Application No: BR/213/21/HH
Site Address: 12-14 The Steyne Bognor Regis PO21 1TP
Description of works: Erection of front porch extension, installation of first floor double balcony and external facade alterations (This application may affect the character and appearance of The Steyne, Bognor Conservation Area)

Thank you for your internet representation made on 13th November 2021 which has been recorded as an objection with the comments as follows:

DRAWING: Front Facade Alterations			
TITLE: Proposed Plans and Elevations			
SCALE AT A1: 1 : 50	DATE: Issue Date	DRAWN: EL	CHECKED: AP
PROJECT NO: The Styn	DRAWING NO: WLD-010-21-05	REVISION:

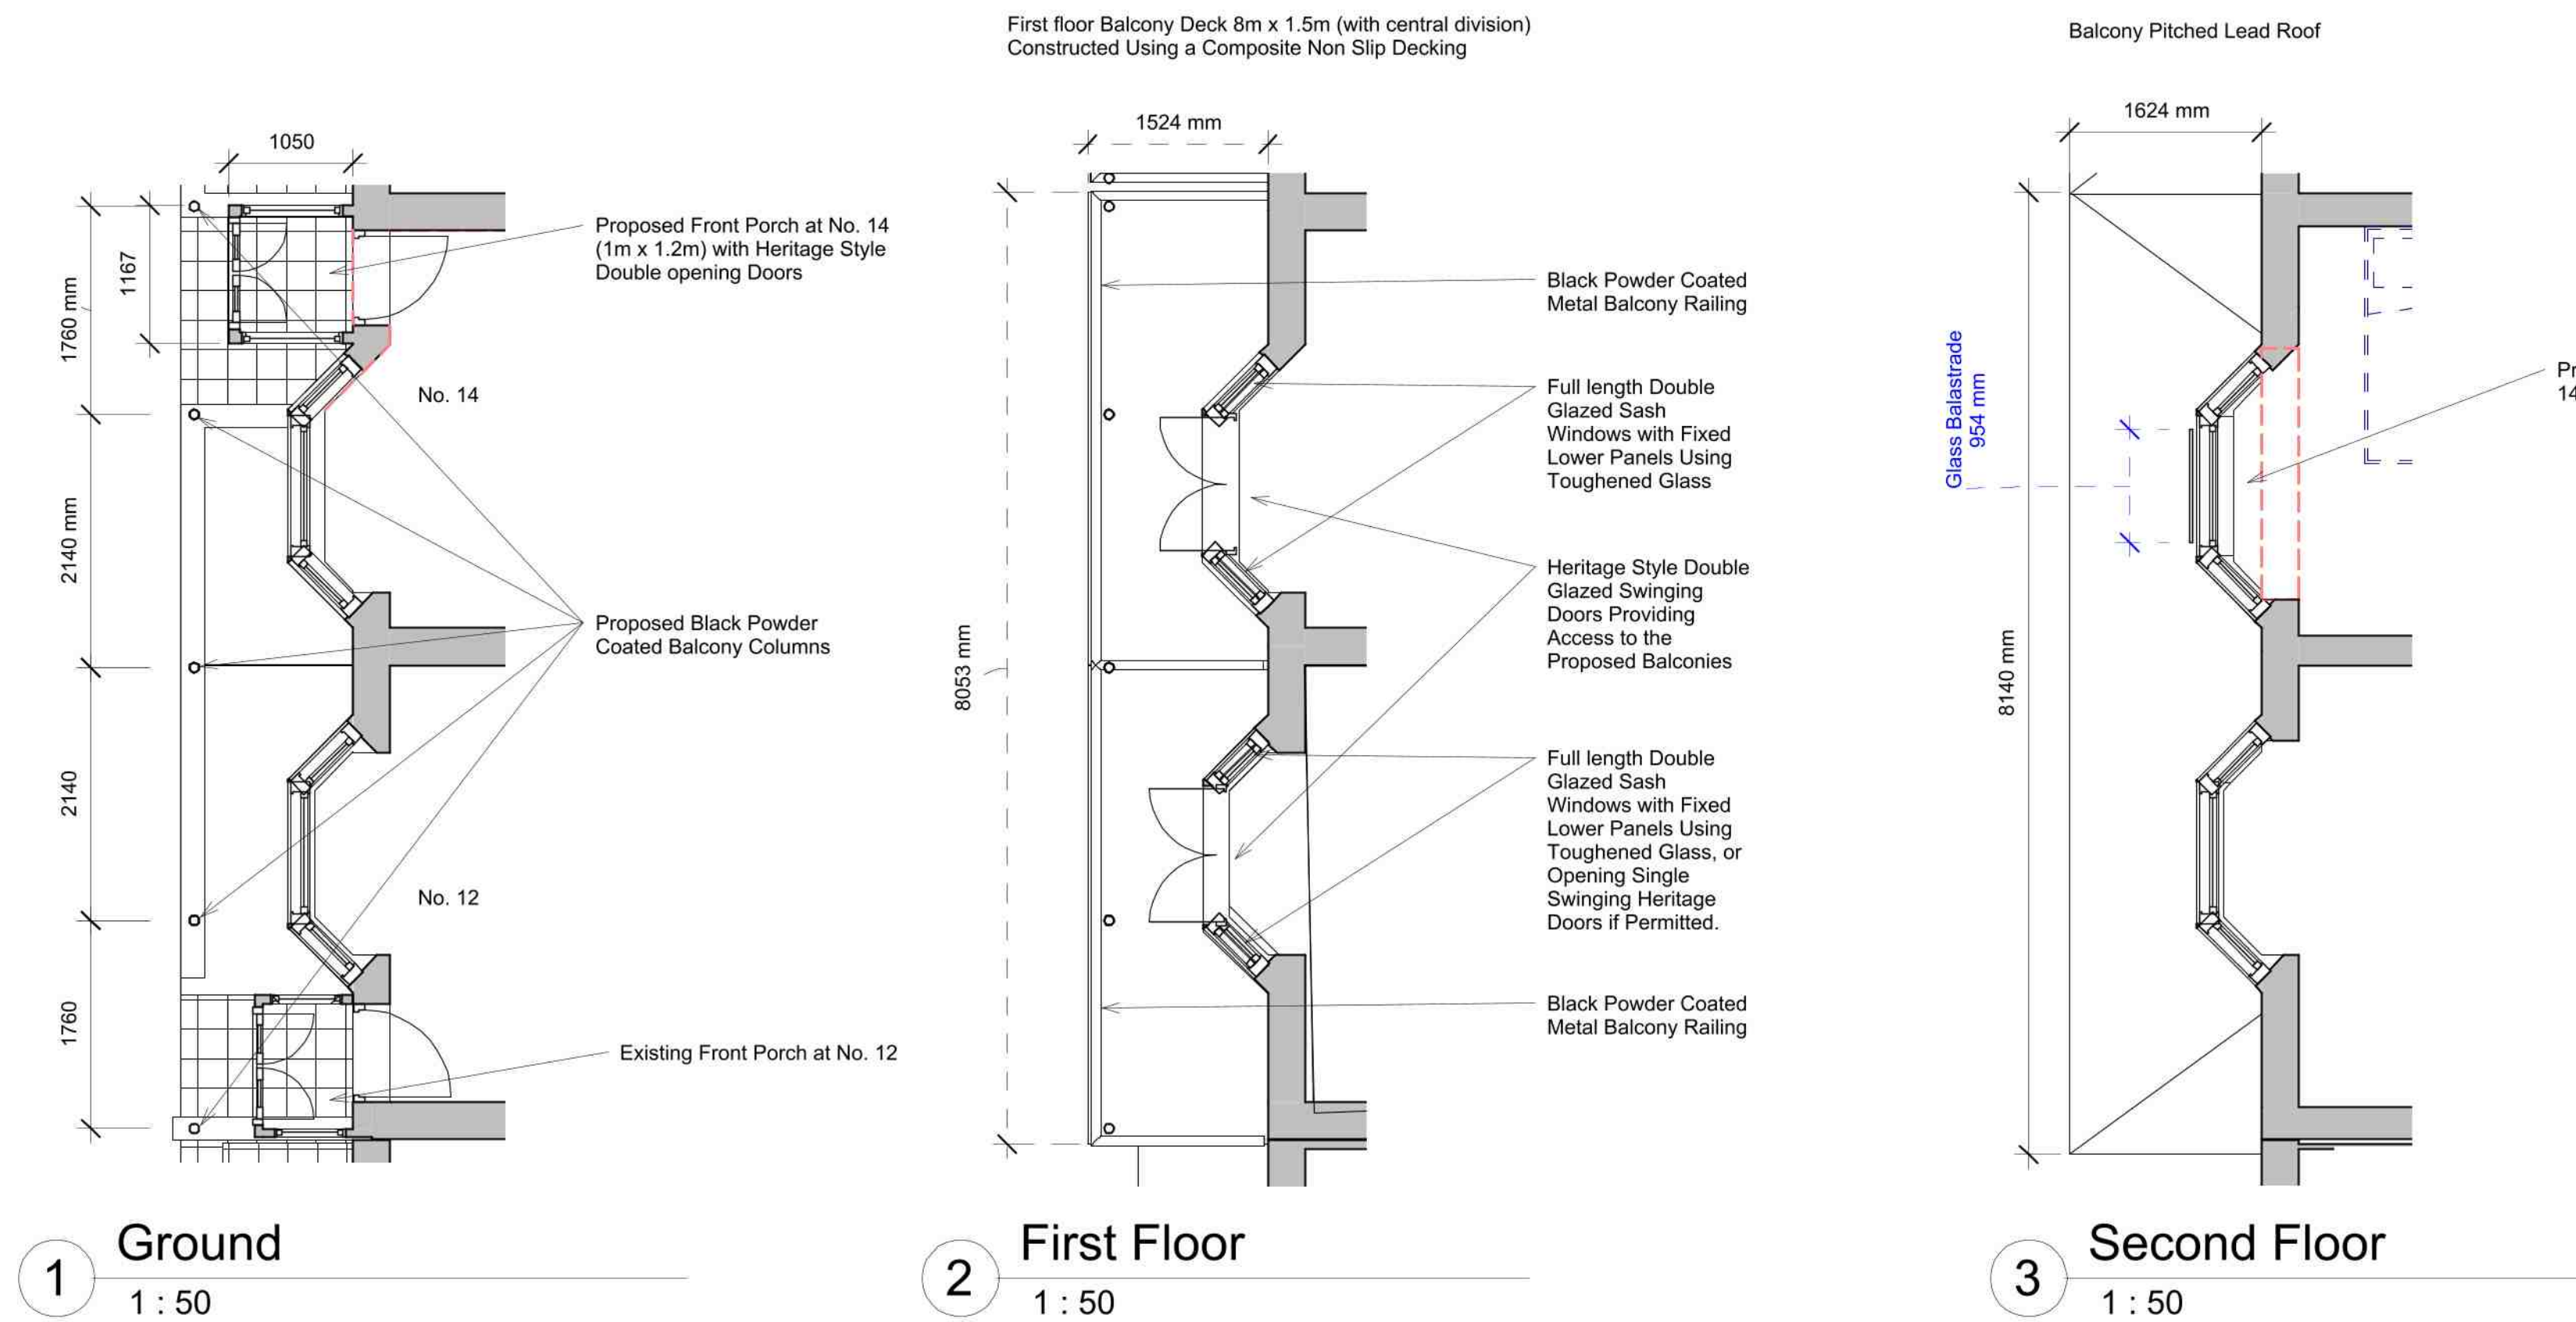
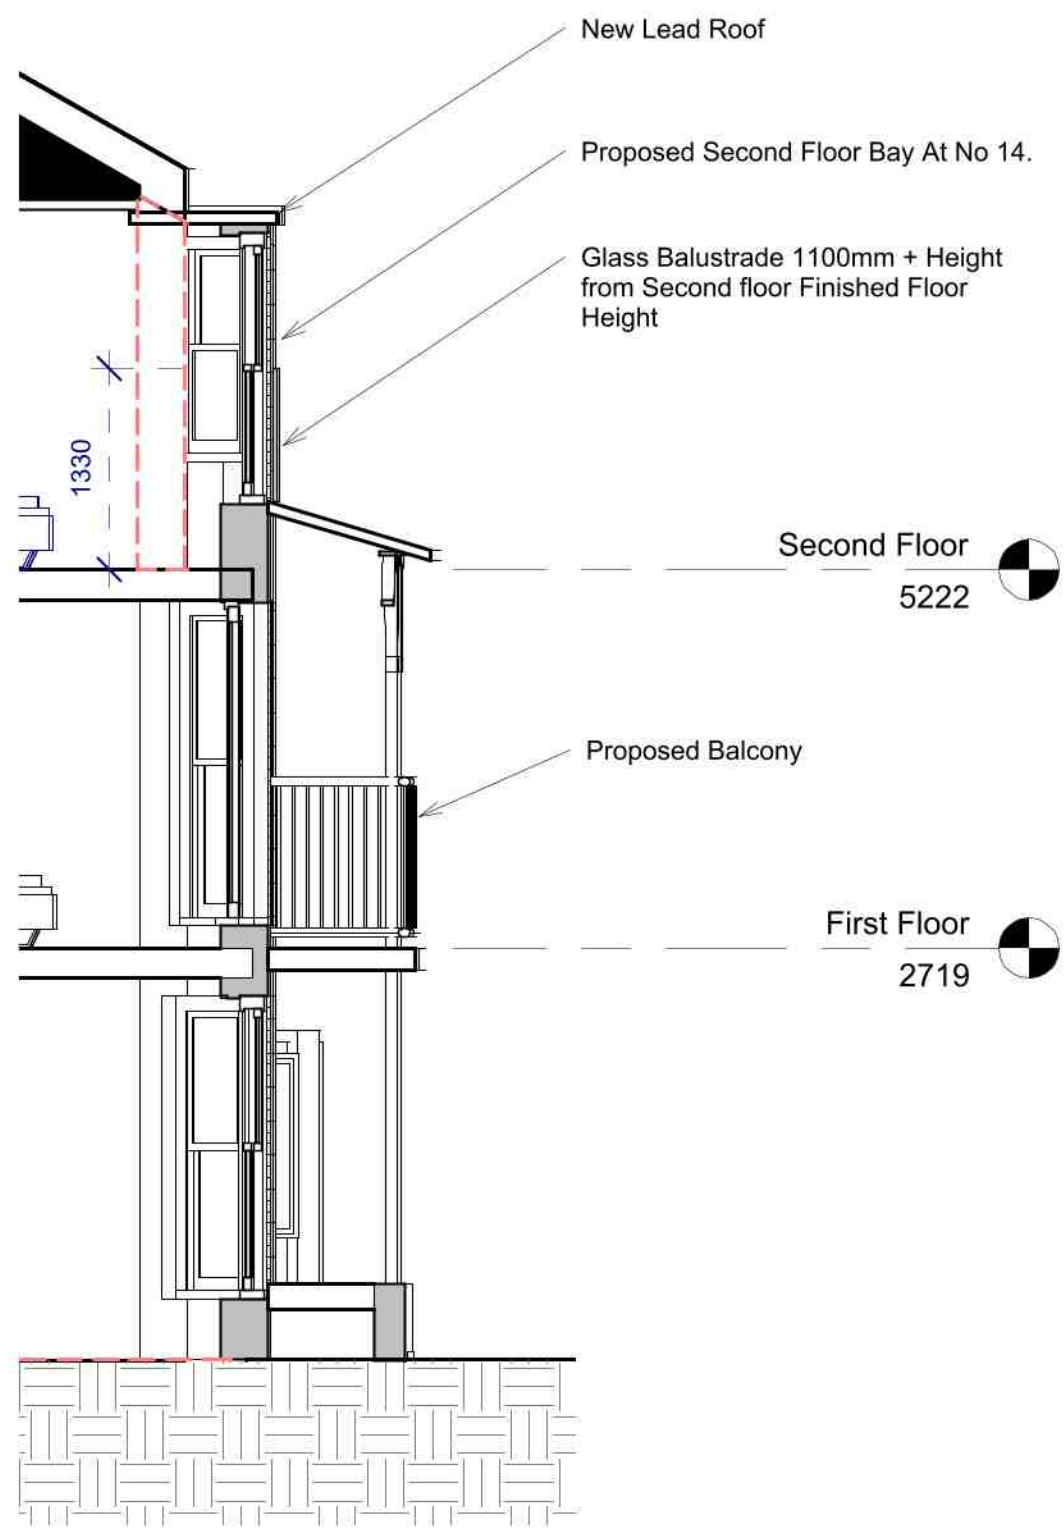
Although I do not object to the erection of the balconies in principle, I do object to the proposed depth of the structures as this is greater than the existing balconies on the neighbouring and nearby properties and will protrude out significantly.

In addition, the proposed glass Juliet balcony on the upper floor is not in keeping with the facades of the properties in this part of the Steyne Conservation area.
